**RESPONSE TO THE SECRETARY OF STATE FOR ENERGY SECURITY AND NET ZERO'S REQUEST FOR INFORMATION AND UPDATES (DATED 3/3/23) FROM DAVID LANGLEY**

**CONSIDERATION OF ALTERNATIVES**

**Plate 2.2 - England South Coast Map showing the region and ten connection sites identified**

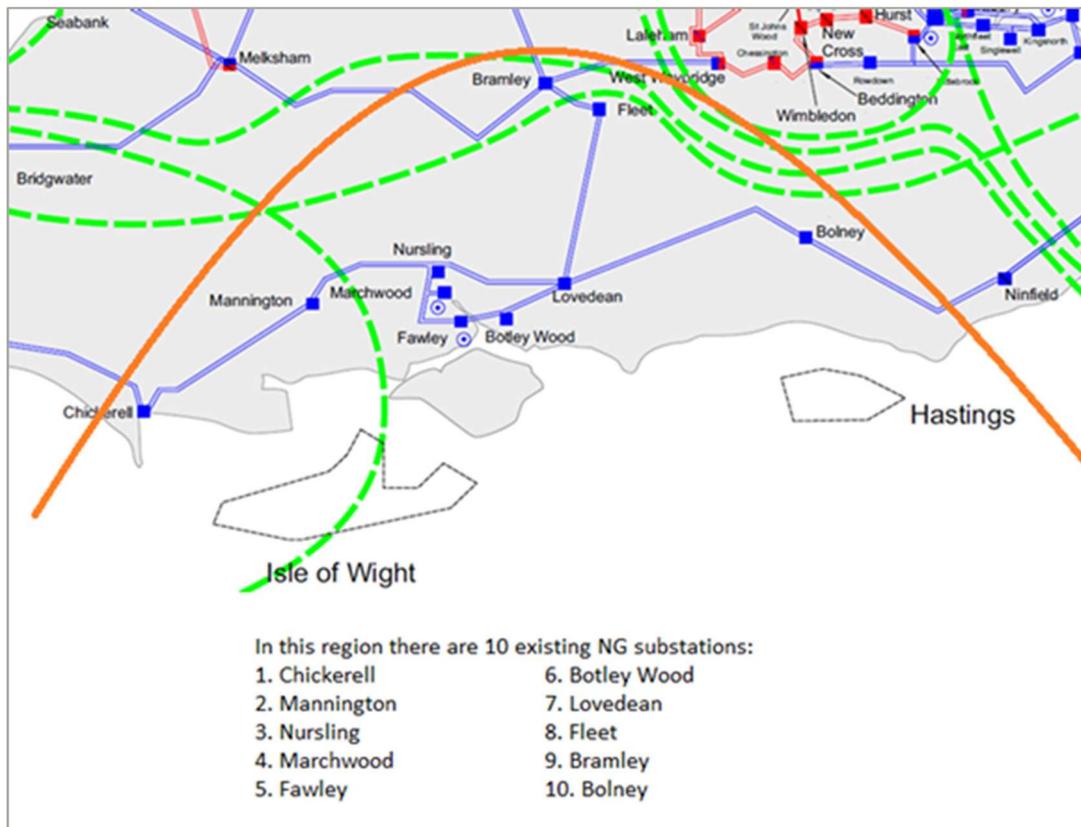
This diagram, Plate 2. 2 in the [Environmental Statement Volume 1](#) (PINS Ref.: EN020022) Chapter 2, page 2-8, is a map-like illustration representing part of the South coast of England. On closer inspection it is, in fact, rather confusing, having the word “Hastings” floating off-shore, nowhere near where Hastings actually would be on the map! Likewise, the Isle of Wight appears to be adrift!

This diagram/map has a parabola superimposed over it. The parabola encloses Portland Bill to the west and Eastbourne and Beachy Head to the East. The area within the parabola contains, we are invited to accept, those substations (10 in number), deemed suitable for the Aquind Interconnector to use as a connection point into the 400kv grid.

By implication, **substations outside this limited area are to be considered either not suitable, not viable or simply not to exist.** This misleading diagram has been used for all formal analysis; by the planning inspectors, by BEIS and by the Judge at the examination of the BEIS’ decision in the Royal Courts of Justice.

This parabola excludes, among others, one substation which could be far more suitable for connection into national grid lines, namely Ninfield.

The misleading nature of Plate 2.2 is clearly evident when it is laid over a map showing the English Channel and the North coast of France from Calais in the east to Cherbourg in the West (see above). Such an overlaying clearly indicates the way in which misunderstanding is planted in an observer's mind.

It is possible that Plate 2.2 was drawn up at the same time that Aquind presented a diagram indicating that the landfall on the French side was in the Baie de la Seine near Le Havre. It is conceivable that Aquind did not think it necessary to redesign their presentation material, Plate 2.2, after the connection point in France had been moved Eastwards to just outside Dieppe.

Had the same parabola been used with Dieppe as the departure point on the French coast, different substations along the South Coast of England would have been included in the optioneering.

We suggest that a revision to Plate 2.2 with France to the South, including substations to the East of Bolney and showing correct orientation in relation to the connection point near Dieppe, would have been a more true representation of the options for landfall on the south coast of England. Could it be that the planning inspectorate, the BEIS and the High Court Judge were all being guided by visual material that was misleading?
